**Subject: Westgate Mall Redevelopment Phase 1 – Site Plan Update Letter**

This letter has been prepared in correspondence to City comments regarding the “Westgate Mall Redevelopment Phase 1 – Site Plan Update Letter” received in July 2020. Each of the City comments are listed below which are then followed by the respective response:

SHEET TITLE:
SITE PLAN

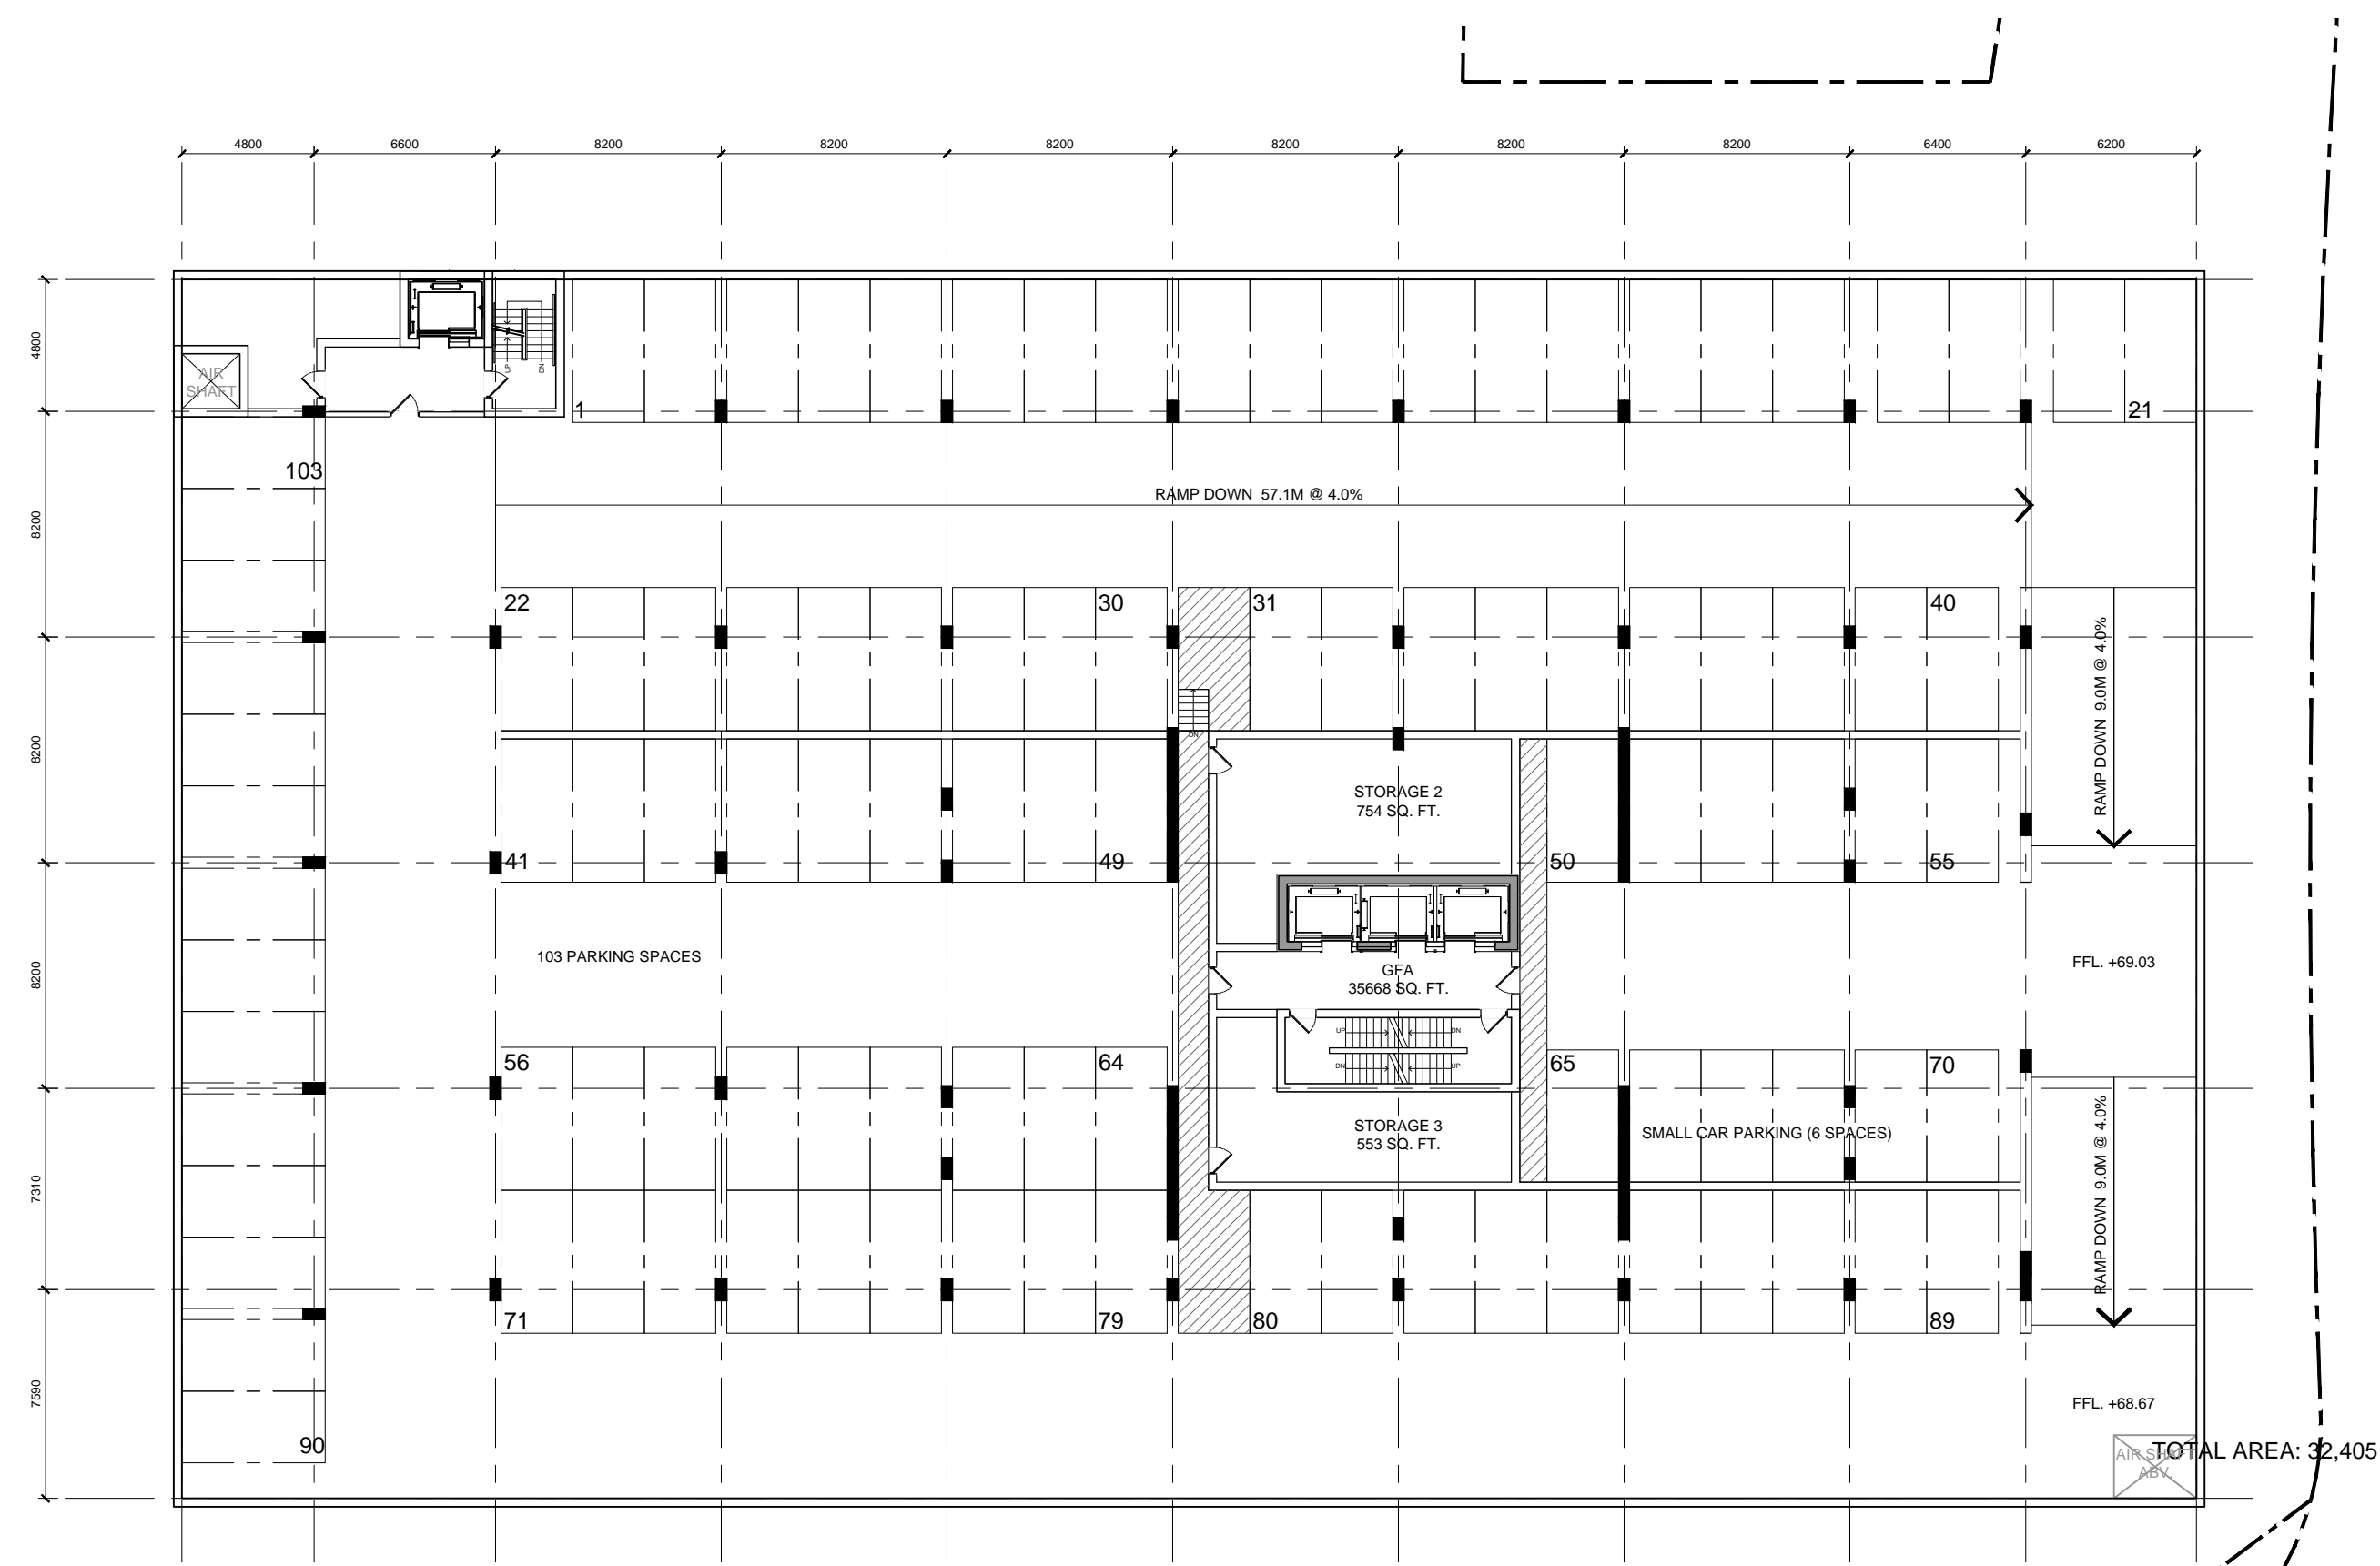
Provide a warning device for vehicles leaving the underground parking to alert them to trucks backing into the truck bays.

In the event that a vehicle comes out of the underground parking while a truck is backing into the loading bay, provide space for vehicles to wait.

Ensure that trucks parked in the loading bay do not restrict cars from exiting the parking garage.

A warning device with in view of the parking garage and a large convex mirror mounted at the north west corner of the loading bays are being provided to alert exiting vehicles and to provide increased visibility while reversing into the loading bay. Figure 1, displays the recommended convex mirror location and two potential locations for a warning device to be installed.

As shown in Figure 2, there is enough space for two departing vehicles to wait on top of the ramp (where one vehicle will be straddling the top of the ramp and the garage door) during periods where trucks reverse into the loading bays. Furthermore, it should be noted that trucks reversing into the loading bays are anticipated to be infrequent, likely occur during off peak periods and will take only a short period of time to complete their maneuvers.

While a WB20 is parked within the west most loading bay, passenger vehicles retain access to the underground parking even with the reduced drive aisle width as shown in Figure 4. WB-20 sized vehicles with the proposed access configuration will likely have difficulties maneuvering into the east loading bay and since the length of a WB 20 (~22.7m) may confine the drive aisle into the garage, it is recommended that signs be posted above the east loading bay to restrict truck size to shorter vehicles such as the WB 15 (~16.7m) or smaller.
